# TRAFFIC IMPACT STUDY

**Jaynes Property**  
**El Paso County, Colorado**  
PCD File No. SKP225

November 2022  
Revised:  
January 2023

SKETCH PLAN

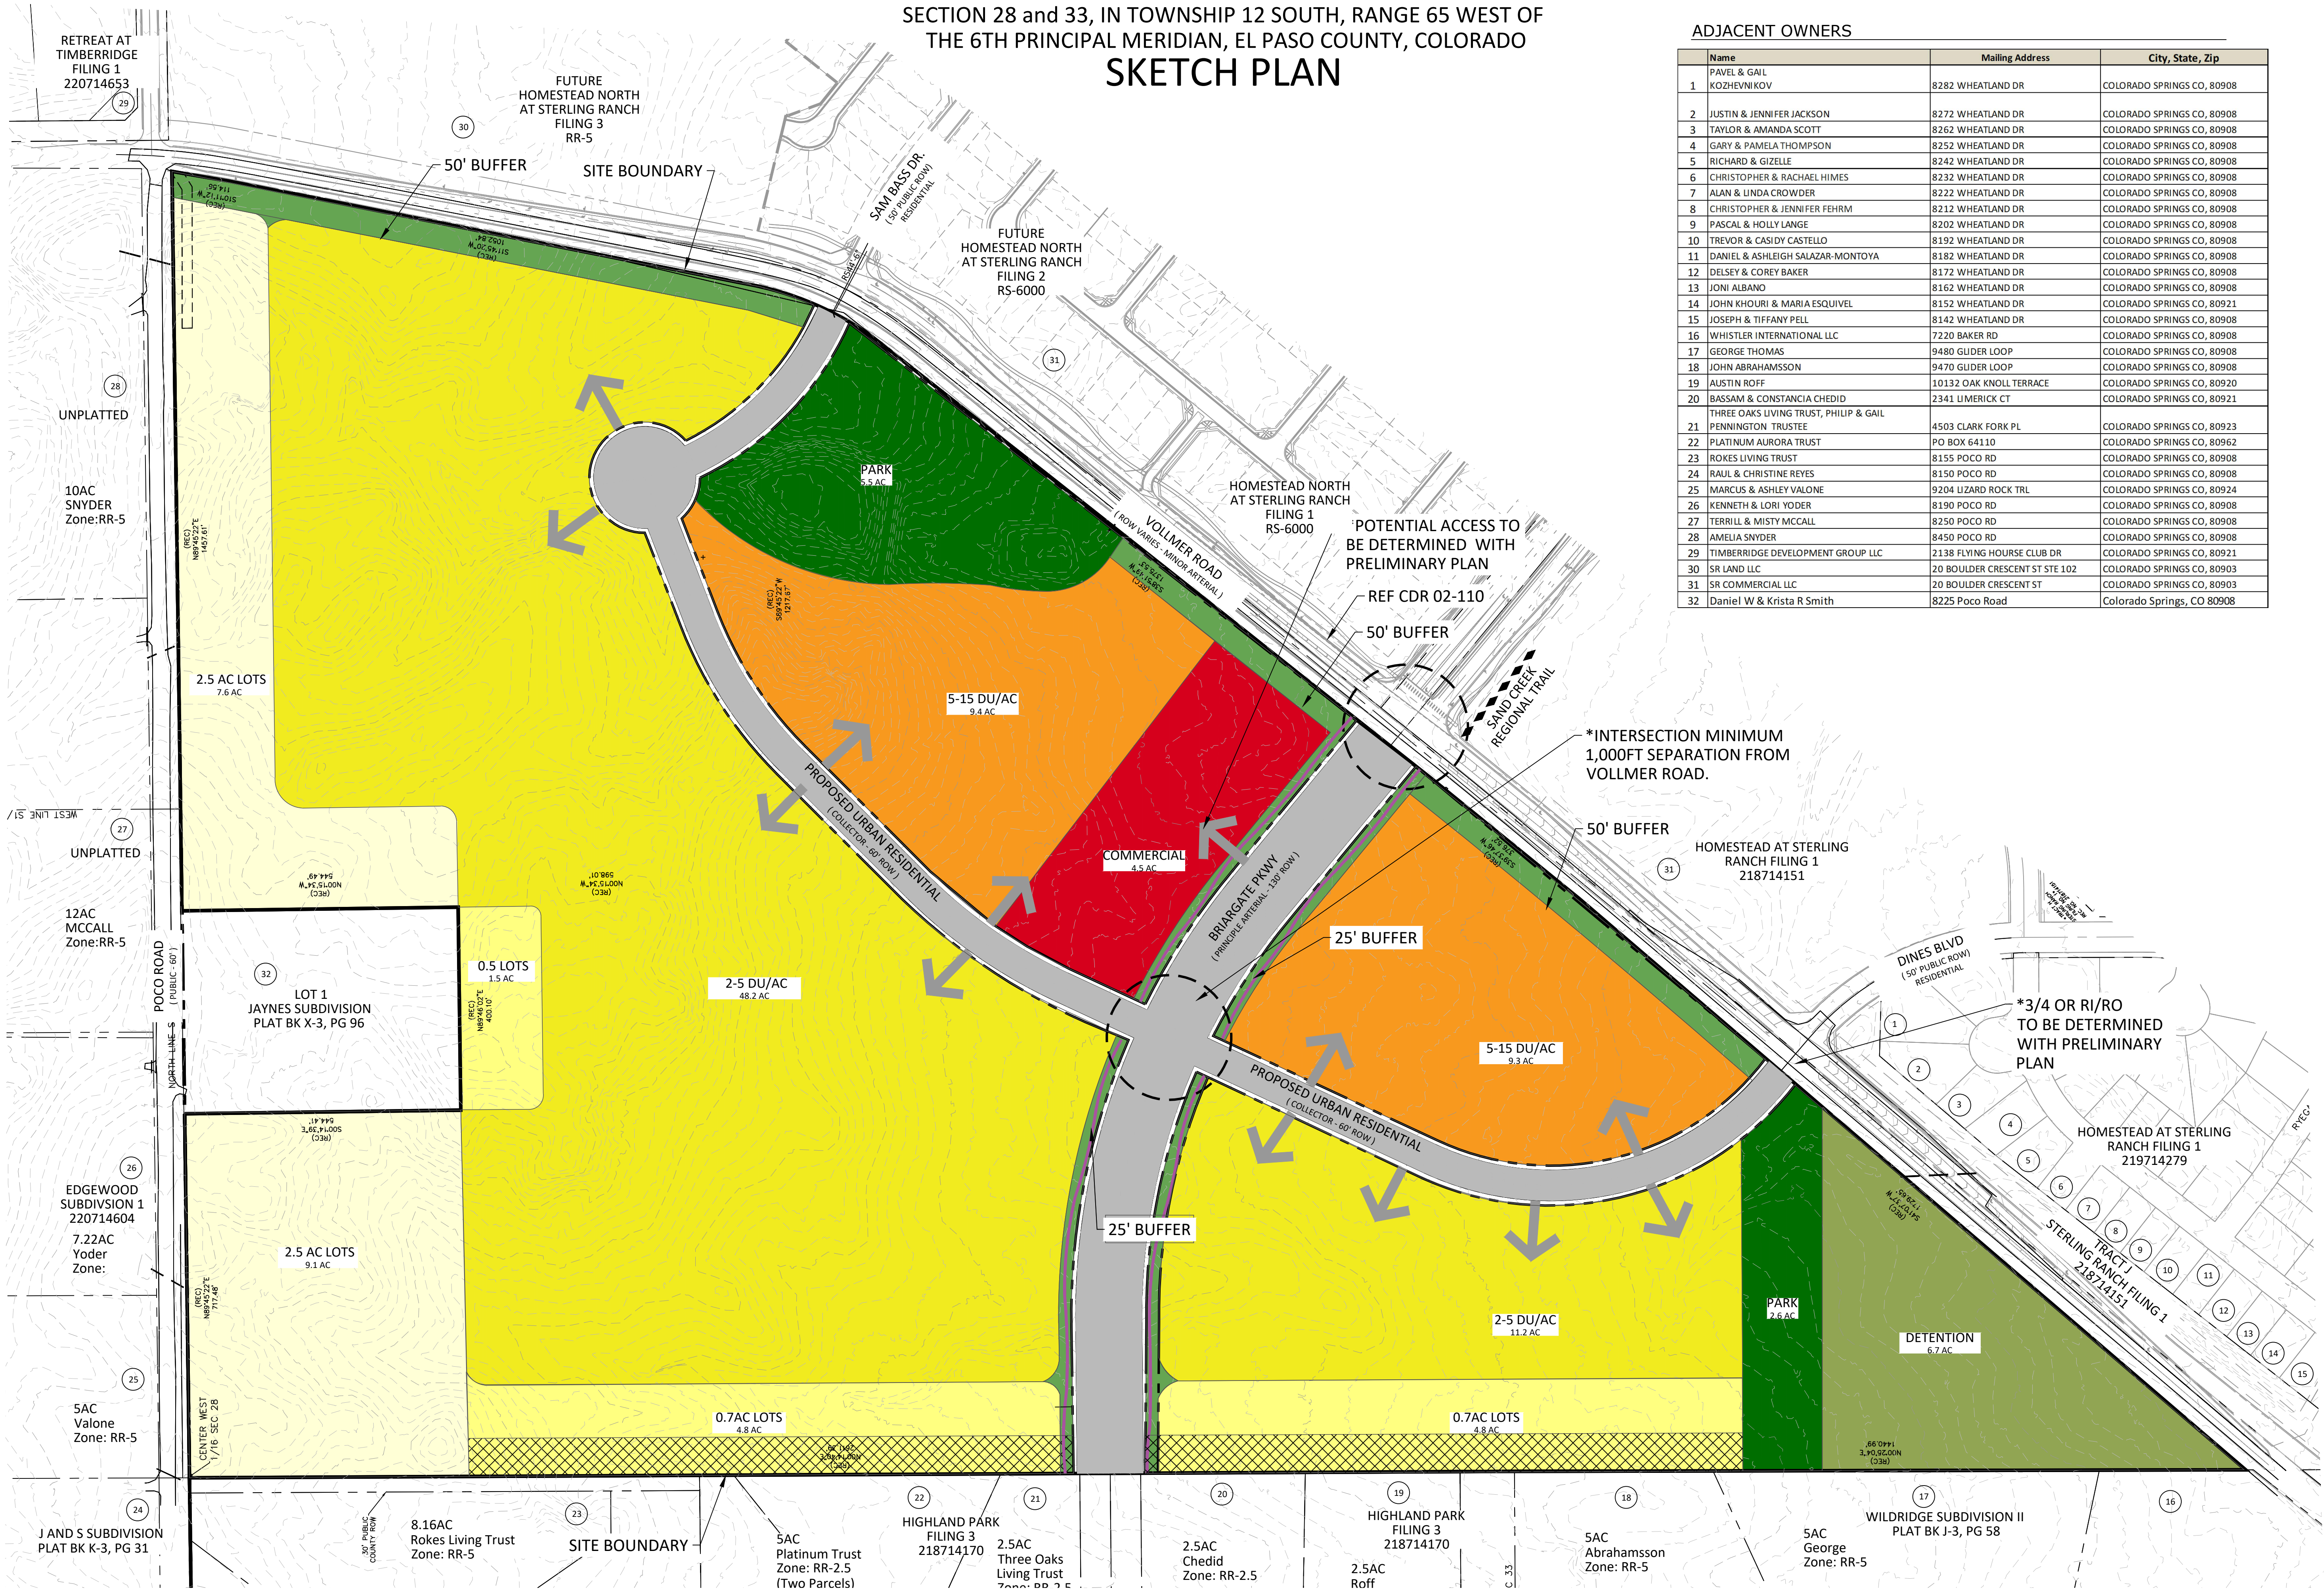
Clarify - full movement is unlikely here; possibly RI/RO or 3/4 only because of vertical alignment on east side.

Discussion added for clarification.
